From: Zac Denton
Sent: 26 November 2019 08:34
To: Planning Scanning
Subject: FW: Seahaven - EP/75/19/PL

WEST ELEVATION

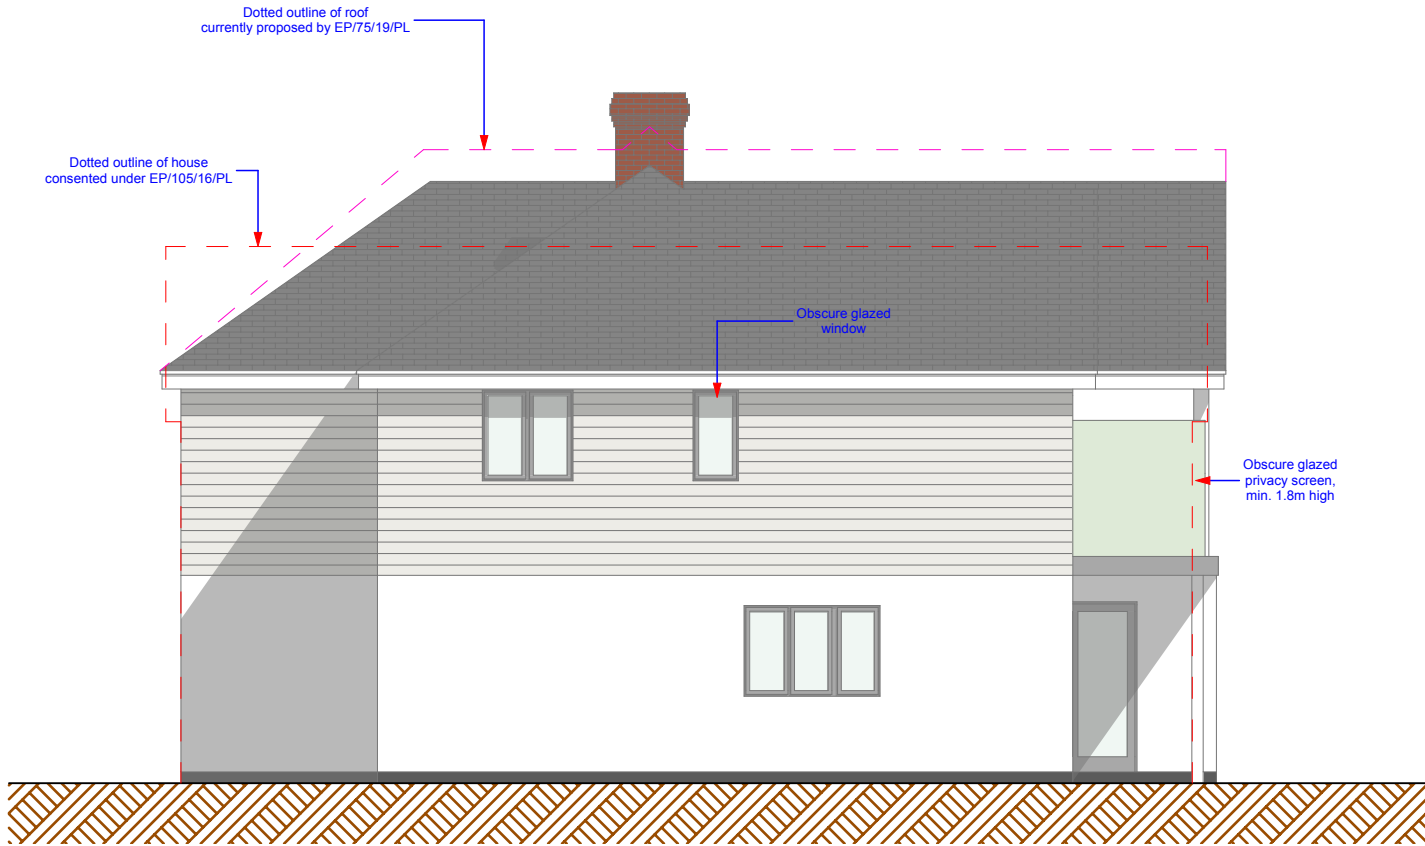
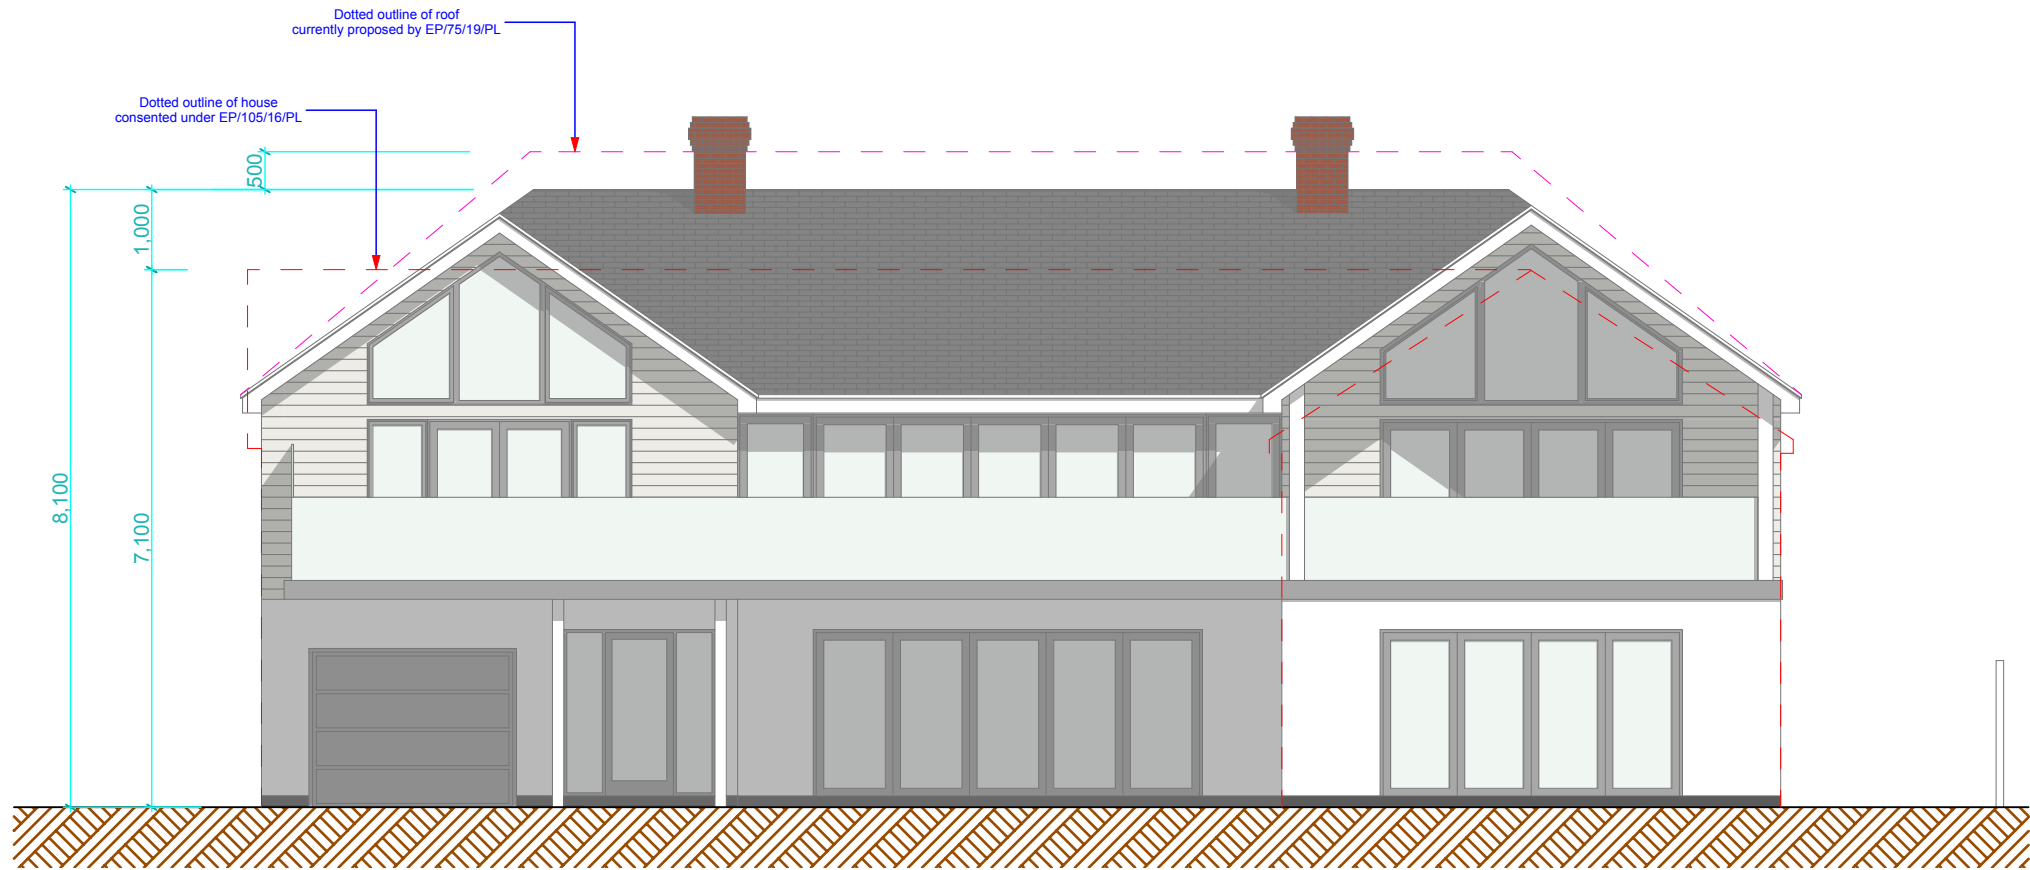
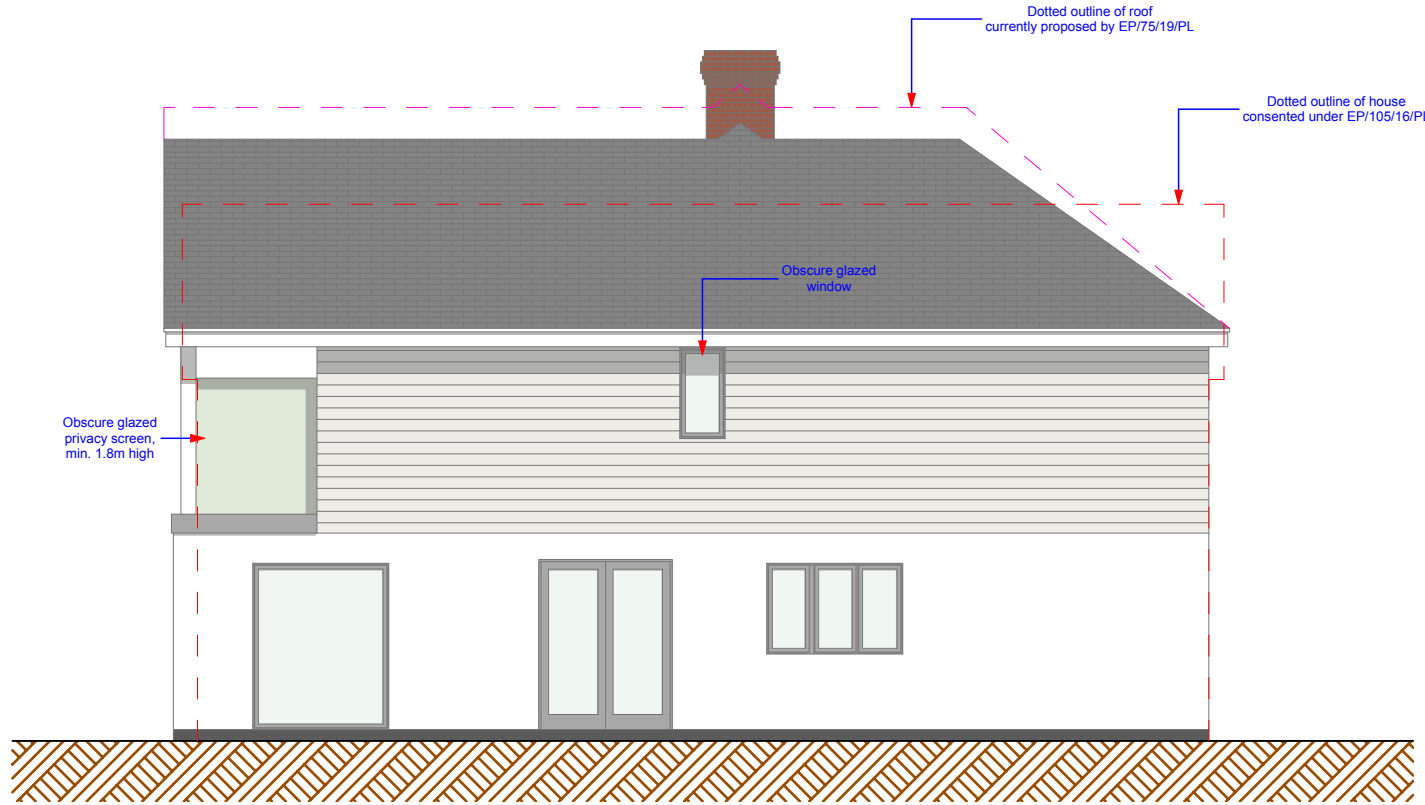
However, the objection is rooted in that the western first floor bedroom window provides serious and harmful overlooking of the sitting out space at Ash Hollow as depicted by the attachment. To delete this window and introduce a substitute window to the north elevation will have a similar negative impact on the neighbouring property to the north.

Further to our conversation I can confirm that we will remove the West facing window in Bedroom 3 and introduce a skylight above 1.7m to bring natural light into this Bedroom. Please could you confirm that if I make this amendment and forward revised drawings that the application will be approved.
